From: Louise Crane
Sent: 04 July 2018 15:08
To: Planning.Responses
Subject: BR/52/18/PL

Comments from Private Sector Housing:

First Floor Plan (Proposed) 1:100

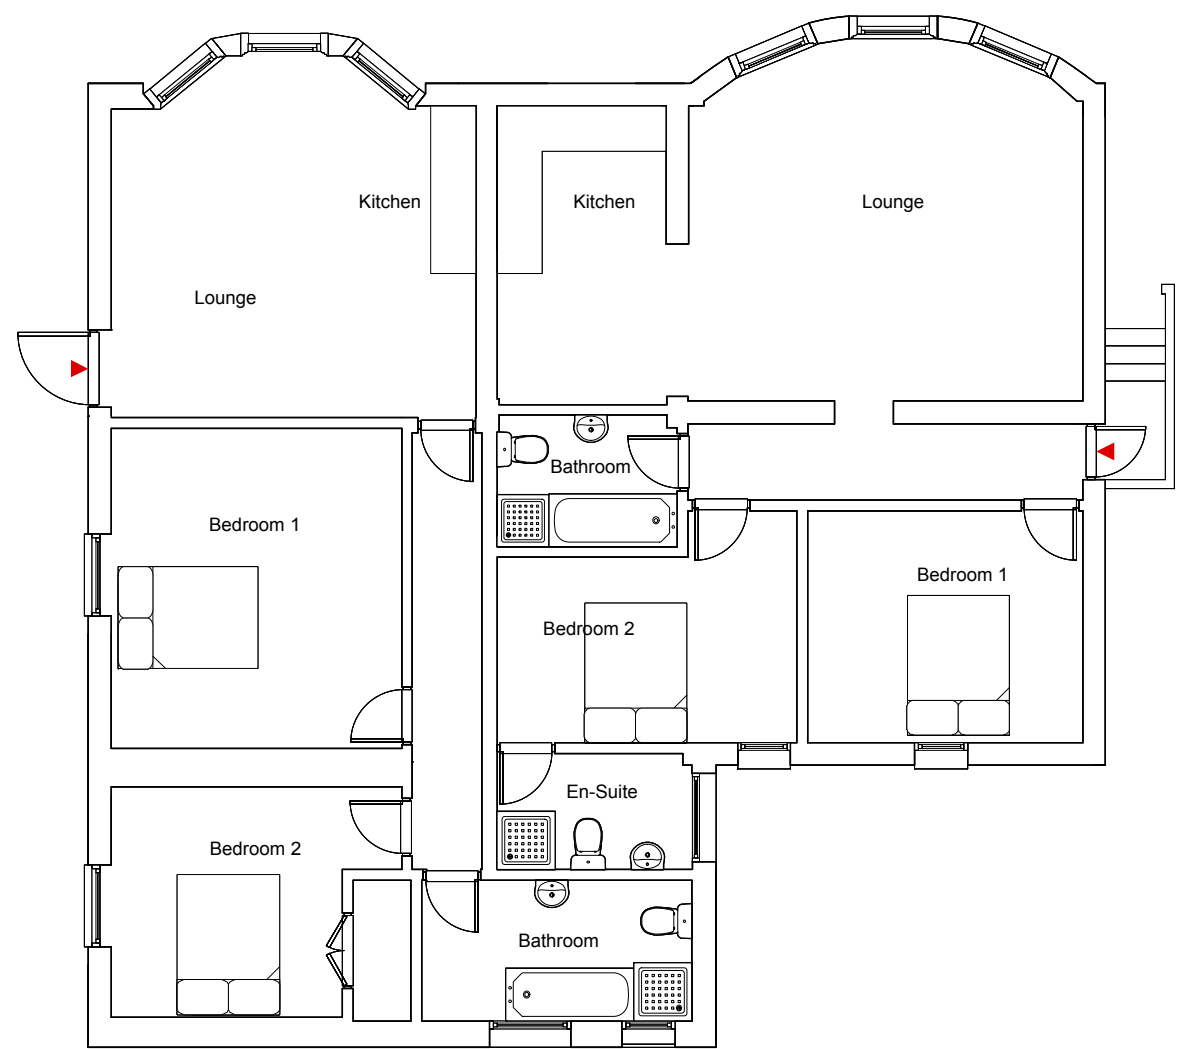
- Appropriate fire precaution facilities and equipment must be provided of such type, number and location as are considered necessary. Guidance on fire safety is contained in the LACORS guidance document – “Housing – Fire Safety, Guidance on fire safety precautions for certain types of existing housing”
- A room where the only escape route is through another room is termed an “inner room” and poses a risk to its occupiers if a fire starts unnoticed in the outer room. The escape routes from all of the flats is via the kitchen/Living room, this can be overcome by ensuring that the window in the bedrooms are escape window and adequate fire protection within the flat. However, an escape window is not acceptable above 4.5m above ground level therefore the layout of the flats on the first and second floor may need to be reconsidered.

Second Floor Plan (Proposed) 1:100

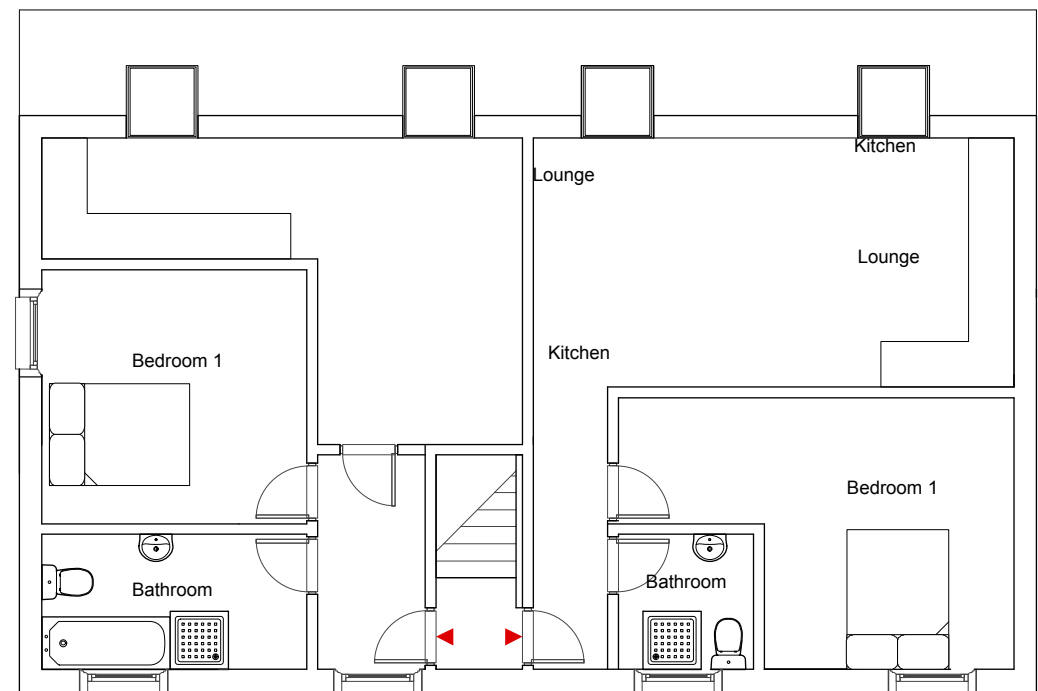
- Must meet the requirements of the Housing Act 2004 and be free of Category 1 and significant Category 2 Hazards;
- The use of skylights as the only windows within habitable rooms (bedrooms and living rooms) whilst they may meet the size requirements for natural ventilation and light, it is not acceptable as these would not provide an appropriate outlook for the occupants of the flat.
